Ribble Valley Borough Council
Church Walk,
Clitheroe,
BB7 2RA

Phone: 0300 123 6780
Email: lhscustomerservice@lancashire.gov.uk
Your ref:
Our ref: LHS/CS/3/2016/0442
Date: 7th July 2016

Proposal:	Change of use of agricultural land to car park for Greendale View Cafe.
Location:	Land at Townhead Farm Downham Road Chatburn BB7 4DL
Grid Ref:	377848 - 444341

Drawing no. 2147: 02 Revision C

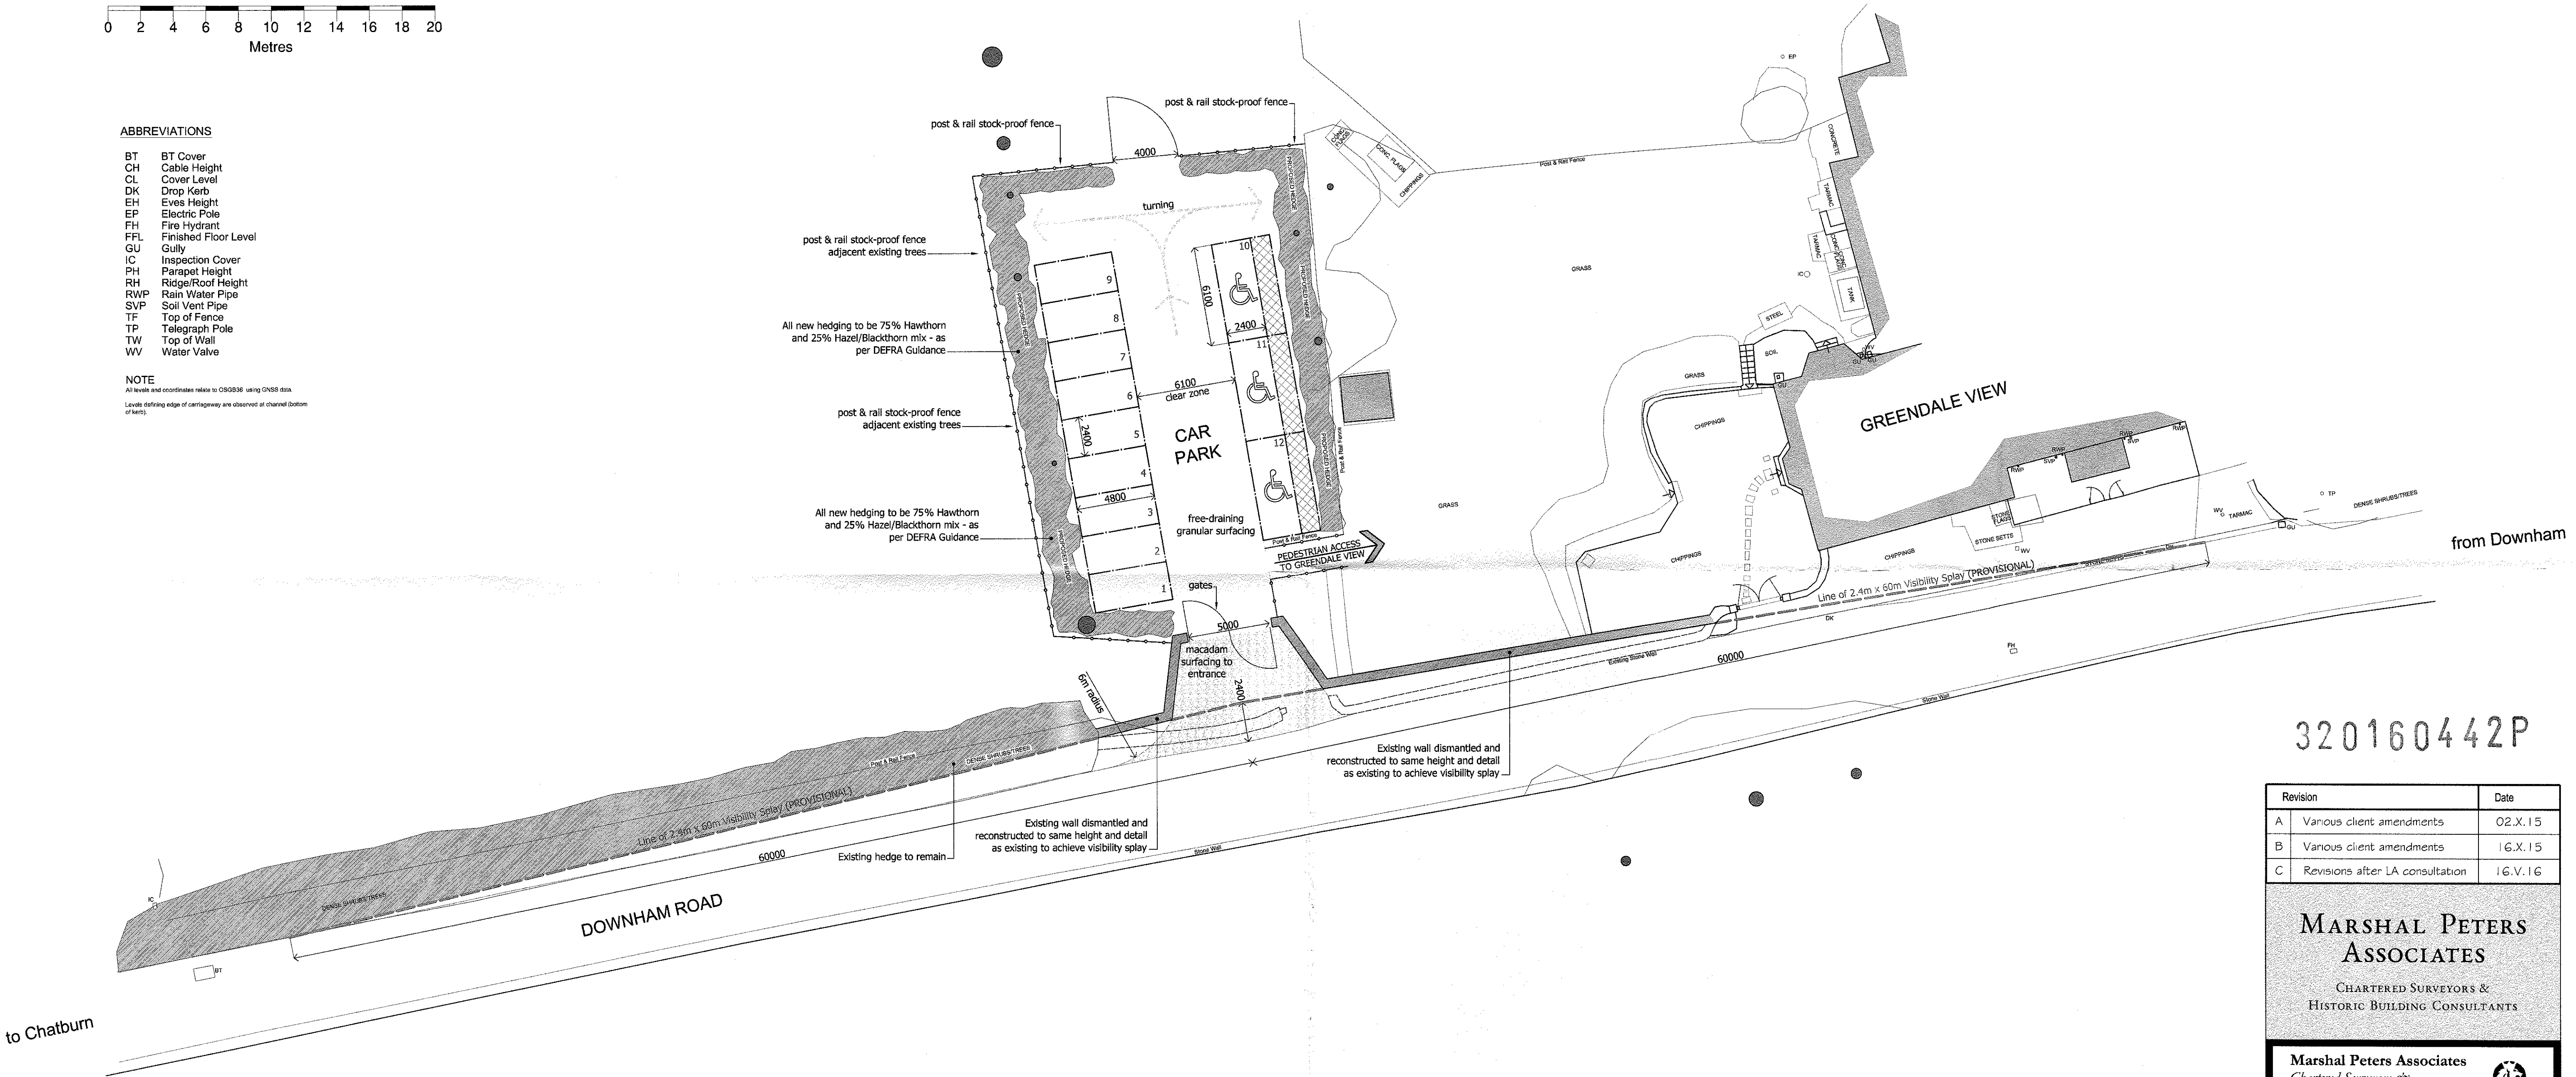
1. Before the access is used for vehicular purposes, any gateposts erected at the access shall be positioned 6m behind the nearside edge of the carriageway. The gates shall open away from the highway. Reason: To permit vehicles to pull clear of the carriageway when entering the site and to assist visibility.
2. Before the access is used for vehicular purposes, that part of the access extending from the highway boundary for a minimum distance of 6m into the site shall be appropriately paved in tarmacadam, concrete, block pavements, or other approved materials. Reason: To prevent loose surface material from being carried on to the public highway thus causing a potential source of danger to other road users.

3. The layout of the development shall include provisions to enable vehicles to enter and leave the highway in forward gear and such provisions shall be laid out in accordance with the approved plan and the vehicular turning space shall be laid out and be available for use before the development is brought into use and maintained thereafter. Reason: Vehicles reversing to and from the highway are a hazard to other road users, for residents and construction vehicles.

4. No part of the development shall be commenced until the visibility splays measuring 2.4 metres by 60 metres in both directions to be provided, measured along the centre line of the proposed new road from the continuation of the nearer edge of the existing carriageway of Downham Road, to the satisfaction of the Local Planning Authority. The land within these splays shall be maintained thereafter, free from obstructions such as walls, fences, trees, hedges, shrubs, ground growth or other structures within the splays in excess of 1.0 metre in height above the height at the centre line of the adjacent carriageway.
Reason: To ensure adequate visibility at the street junction or site access in the interest of highway safety in accordance with Quality of Development Policy and Transport Policy in the Local Plan.

5. The car parking and manoeuvring scheme to be marked out in accordance with the approved plan, before the use of the premises hereby permitted becomes operative and permanently maintained thereafter. Reason: To allow for the effective use of the parking areas.
